9 May 2022

Response to Submissions St Aloysius College – Rozelle Campus SSD - 27208140

Prepared by Willowtree Planning Pty Ltd
on behalf of St Aloysius College

Figure 12: Pick Up and Drop Off Location

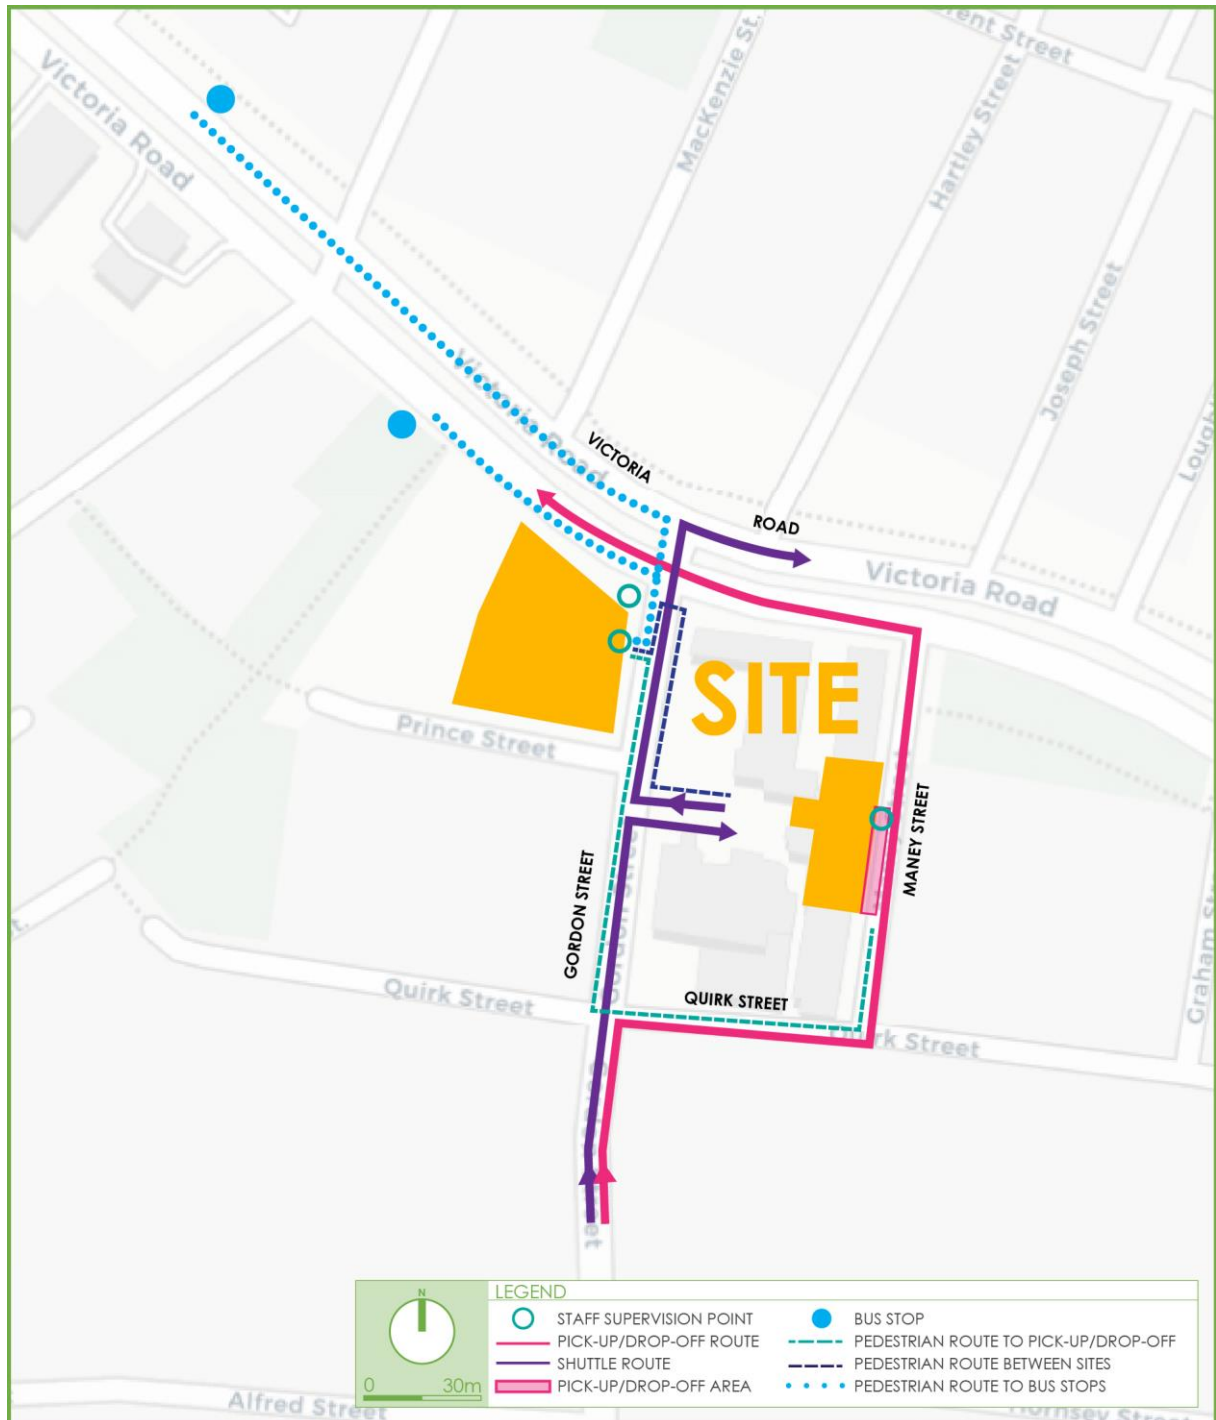
Table 1. DPE Request for Information	
Matter Raised	Response
Pedestrian routes with footpath widths should be included in the TIA	TIA has been updated to include these details (Appendix B).
A Drop Off and Pick Up (DOPU) zone is proposed on the western side of Maney Street. Provide a scaled plan to indicate the accurate location and length. Provide details of alternative DOPU locations.	The TIA shows the location of the proposed DOPU. Many alternative locations have been considered for the DOPU, including along Gordon Street, however it is considered that Maney Street is the most appropriate and least disruptive to traffic flows.
Insufficient information has been provided to clarify the allocation of car parking spaces on the site. Appendix G states that the peak parking demands of other uses on the site will not coincide with the school use. However, according to the Operational Plan of Management, the other uses of the site operate during school hours. The TIA should provide the details of allocated parking for each use on the site including the number of parking spots allocated for the use of the unit which is proposed to be used as the school in the future. In addition to clarifying the allocation, the TIA should also assess the impacts of allocation of 4 spaces to the school, on the other concurrent uses within the sit and proposed mitigations measures if required.	The TIA has been updated to demonstrate the parking requirements of the other uses across the site. It is noted that the school requires four (4) spaces during its operations, the Genesian Theatre requires a maximum of ten (10) parking spaces for staff on site, and SCC requires 15 spaces. As further detailed below in Section 4.2.3 below, these parking demands occur at different operational times and as such there would be no conflict of the uses. This is further details in the TIA (Appendix B).

The pickup and drop off location has been relocated slightly further north on Maney Street, this is to reduce any impacts on the nearby intersections. The revised location is identified in **Figure 2** below. It is considered that these bays would only be required for 30 minute before and after the school day, and at all other hours could be utilised as current resident street parking.

Swept Path Analysis

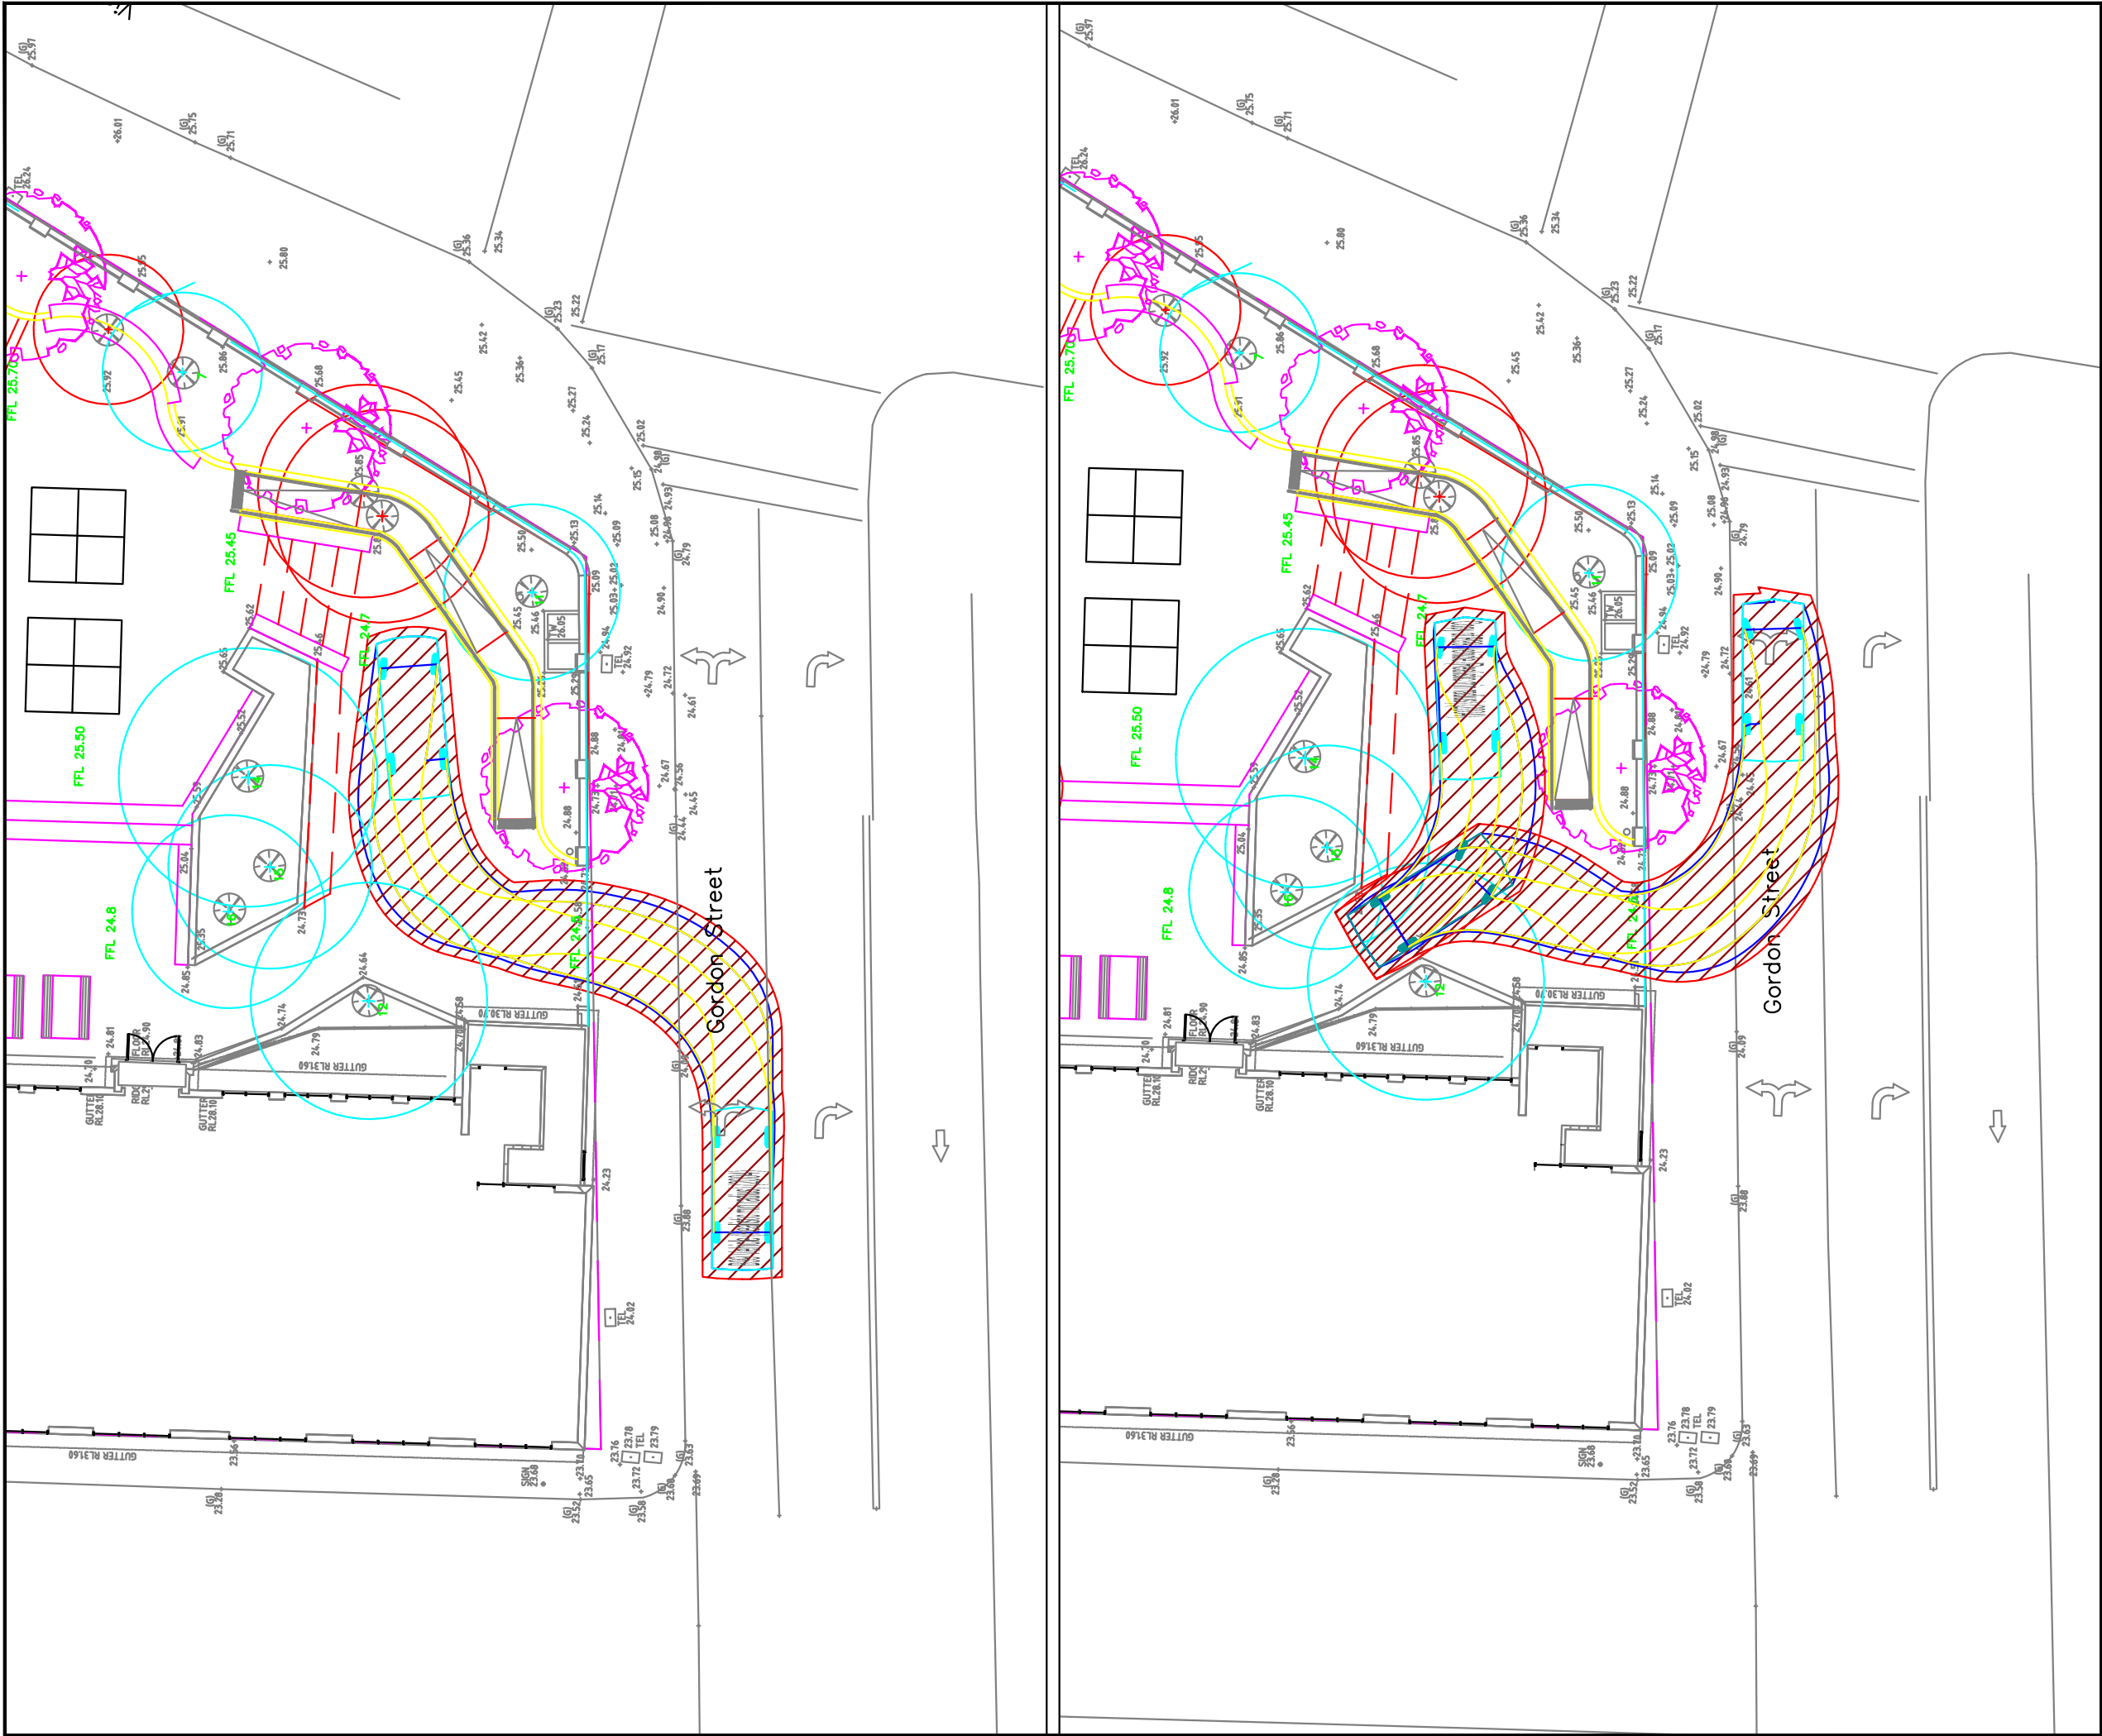
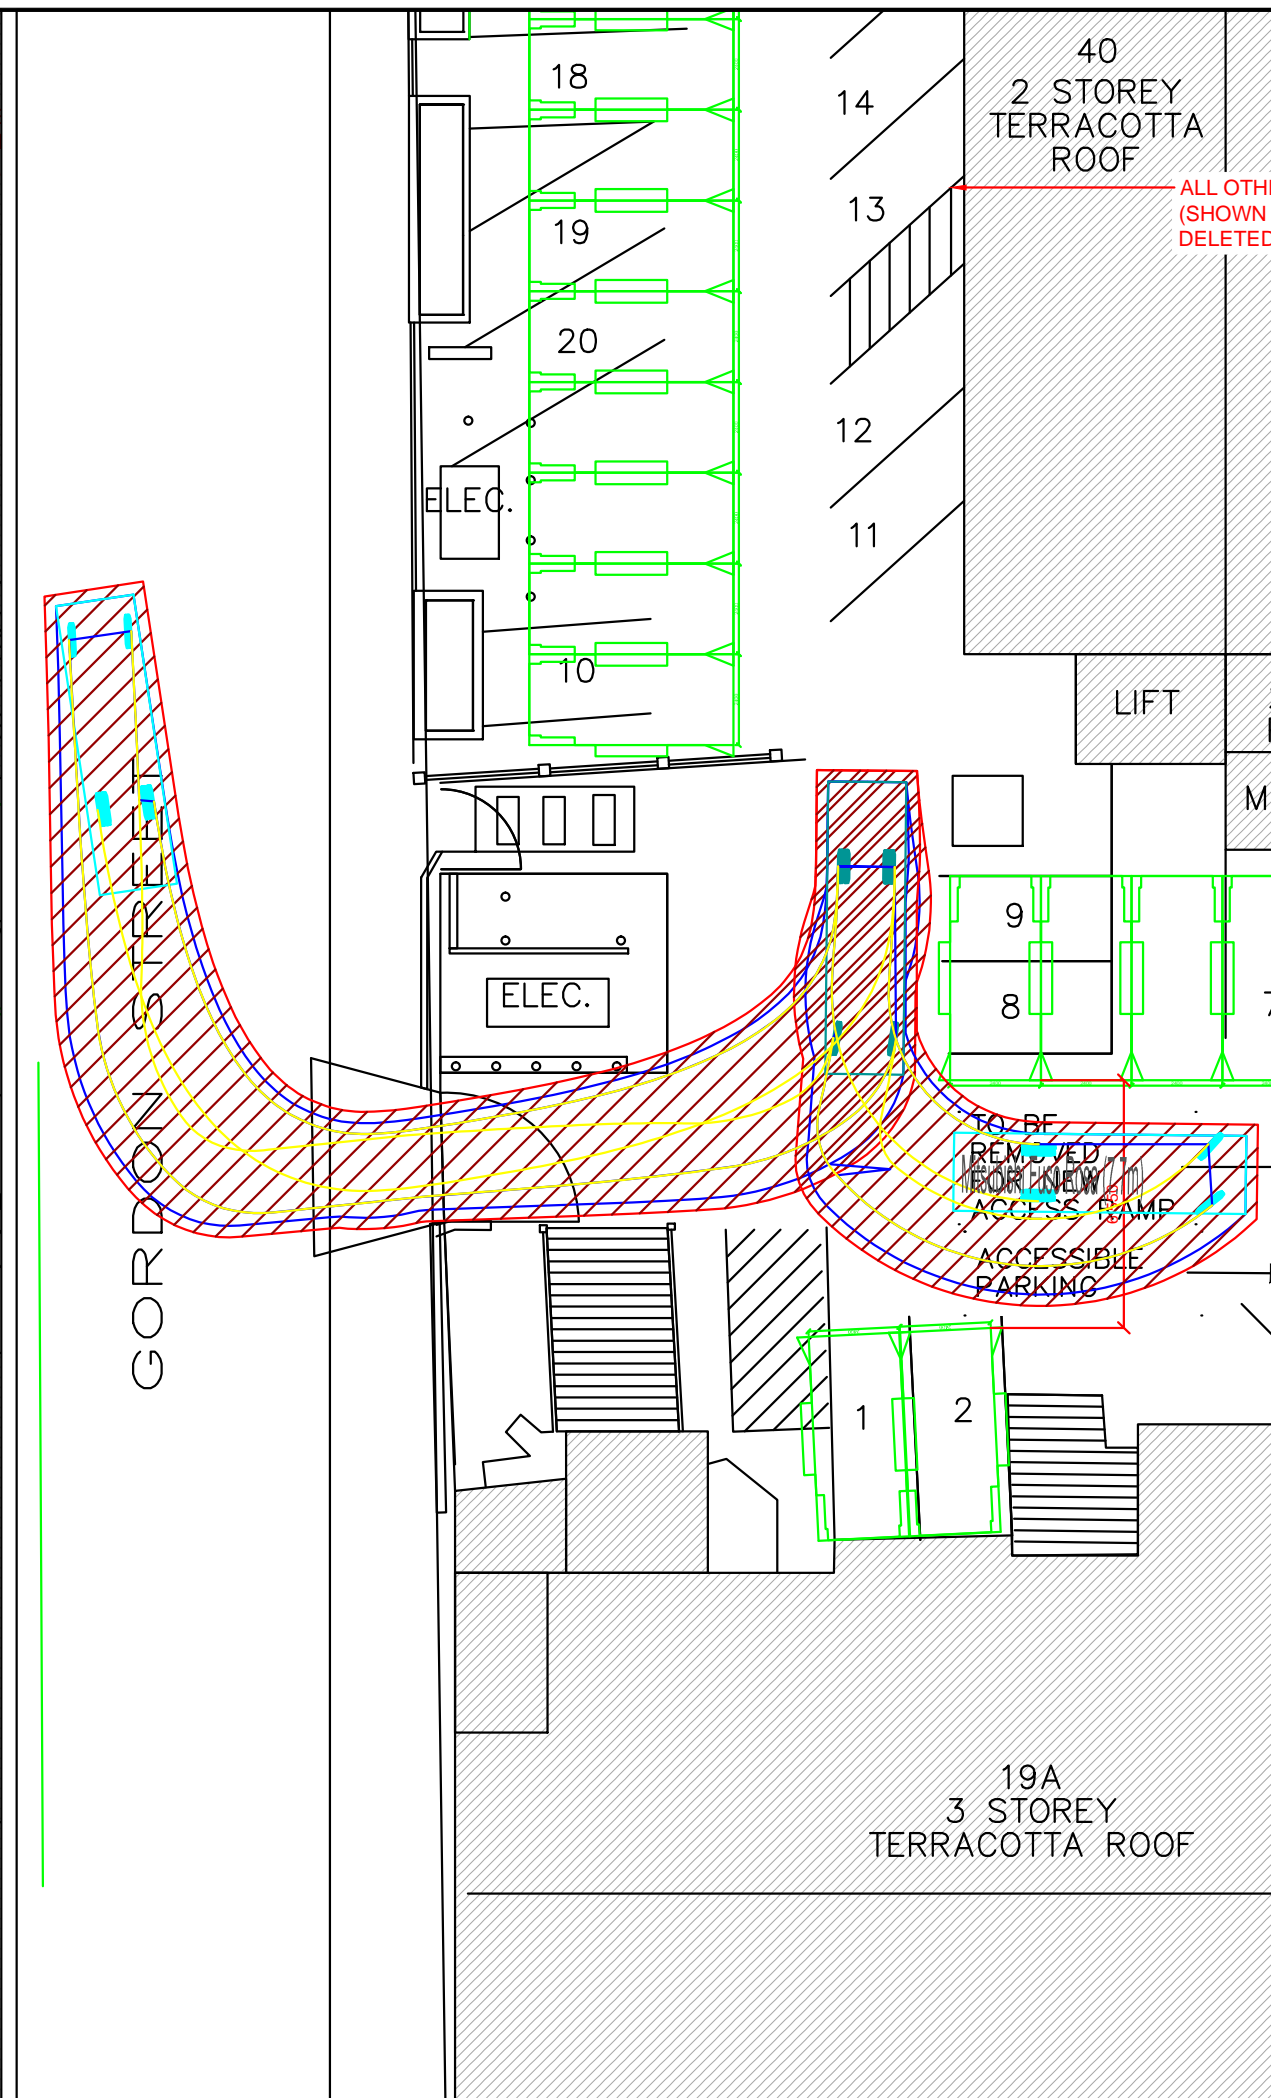
<p>local road should be as far as possible away from classified road (Victoria Road) and existing signalised intersection (Victoria Road / Gordon Street).</p> <p>Recommendation: It is requested that the Applicant be conditioned to undertake a Road Safety Audit (RSA) for the school pick-up and drop off area in accordance with Austroads Guide to Road Safety Part 6: Managing Road Safety Audits and Austroads Guide to Road Safety Part 6A: Implementing Road Safety Audits. The RSA is to be undertaken by an independent, TfNSW accredited, road safety auditor. Based on the results of the Road Safety Audit, the applicant shall review mitigation measures for the operational plan, bus shuttle operation, and determine a suitable pick-up / drop-off location for students.</p>	
<p><u>Swept Paths</u></p> <p>TfNSW notes that the submitted swept paths for vehicles entering the two locations on Gordon Street are not acceptable in their current form (appendix E and F in the Transport Impact Assessment).</p> <p>Recommendation: TfNSW requests that the Applicant addresses this as part of the RtS in which the swept paths showing vehicle entering and exiting the roadway using the current driveways and line-marking through Gordon Street.</p>	<p>A detailed response has been provided at Appendix G and within the updated TIA (Appendix B).</p> <p>Updated swept paths have been included in the TIA.</p>

appropriately managed and monitored by staff to ensure this is done safely and efficiently. Swept path analysis for the shuttles has been provided in the TIA (**Appendix B**) to demonstrate that these buses can manoeuvre into and off the site in a forward direction.
